From: hannah@southonfamily.org.uk
Sent: 11 Aug 2021 08:17:08
To: spayne@S-NORFOLK.GOV.UK,
Subject: RE: 2021/1303 - 11, Bramerton Lodge Shed application
Attachments: image001.jpg, image002.jpg, image003.jpg, image004.jpg, image005.jpg, image006.jpg,

Subject: 2021/1303 - 11, Bramerton Lodge Shed application

Garden Shed and Pergola

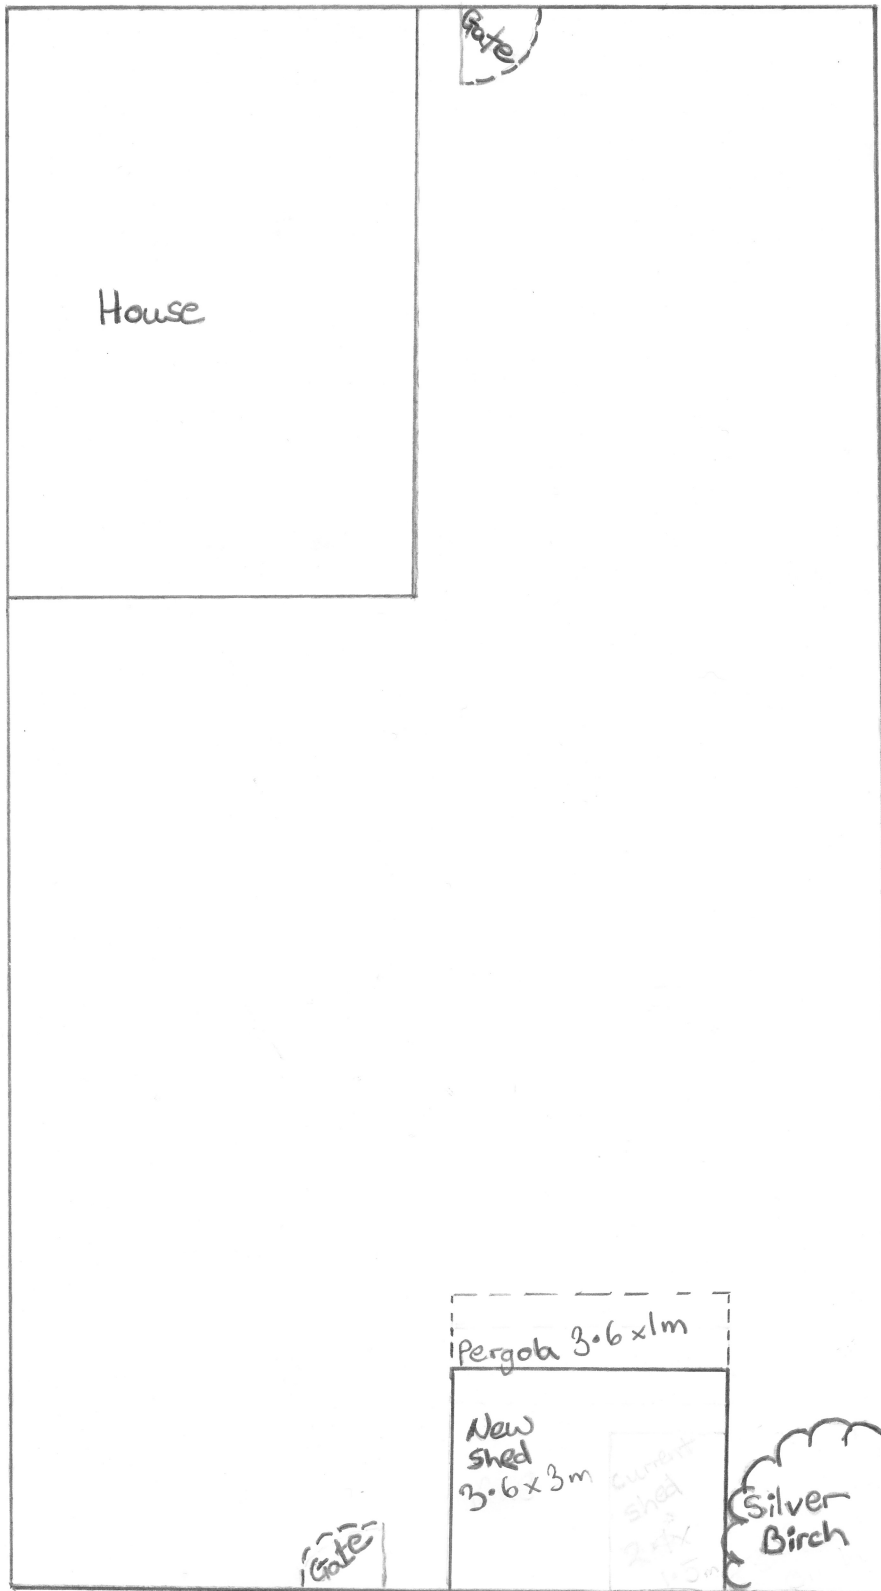
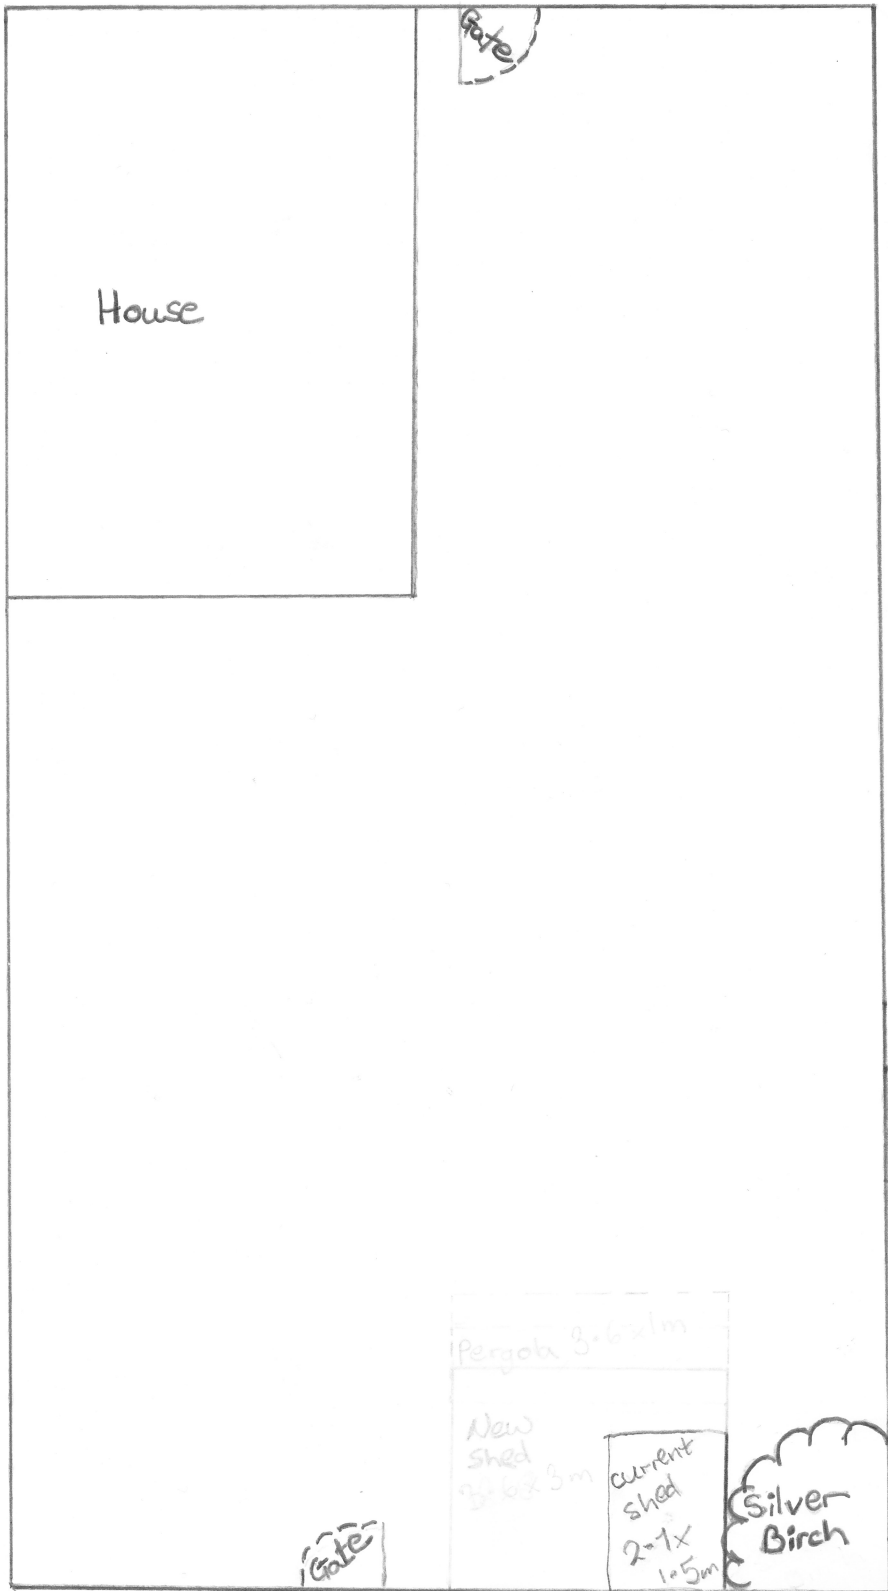
The Floor Plan and Site Plan are to scale. The proposed elevations need to have all the measurements provided on the elevations, up to the eaves e.t.c if this is the format that you are submitting these plans to us, otherwise we will need them to be redrawn to a metric scale of 1:100 or 1:50. The east and west elevations of the shed and the pergola structure need to be provided also.

Attached are the revised scale elevation plans for the shed. I have also attached an elevation plan of just the shed in case that is helpful.

# Elevation Plan

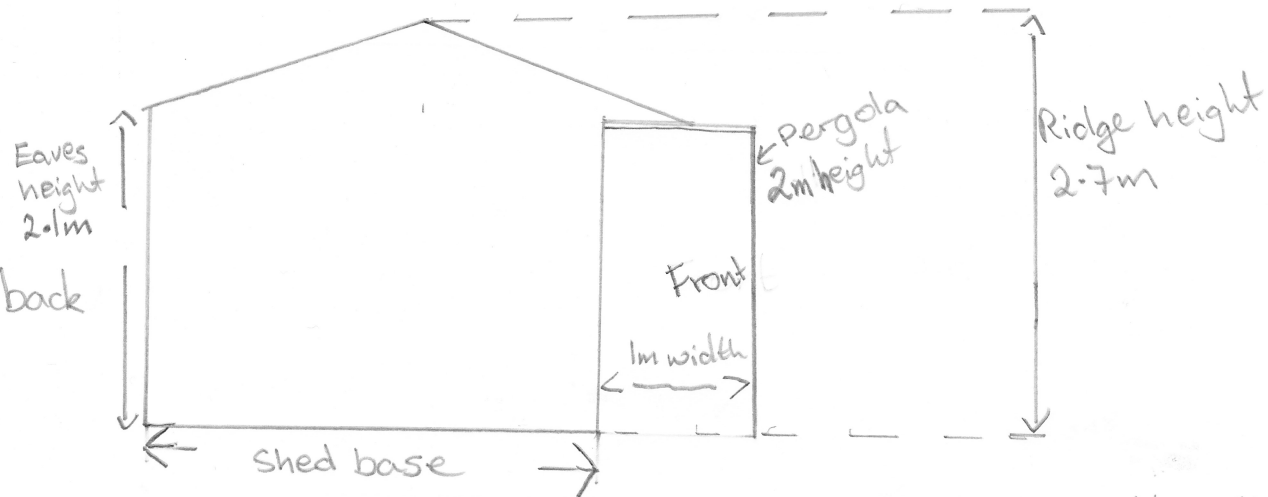
The elevations need to be shown in full with roof details, in its full entirety and all measurements shown to roof height, eaves etc if not drawn to a metric scale please.

The North and South elevations that you have drawn I can accept, thank you. Have you submitted the east and west elevations?

Are these east-west elevation plans acceptable?

No North and South elevations have not been submitted. I will endeavour to send you those this evening, if needed.
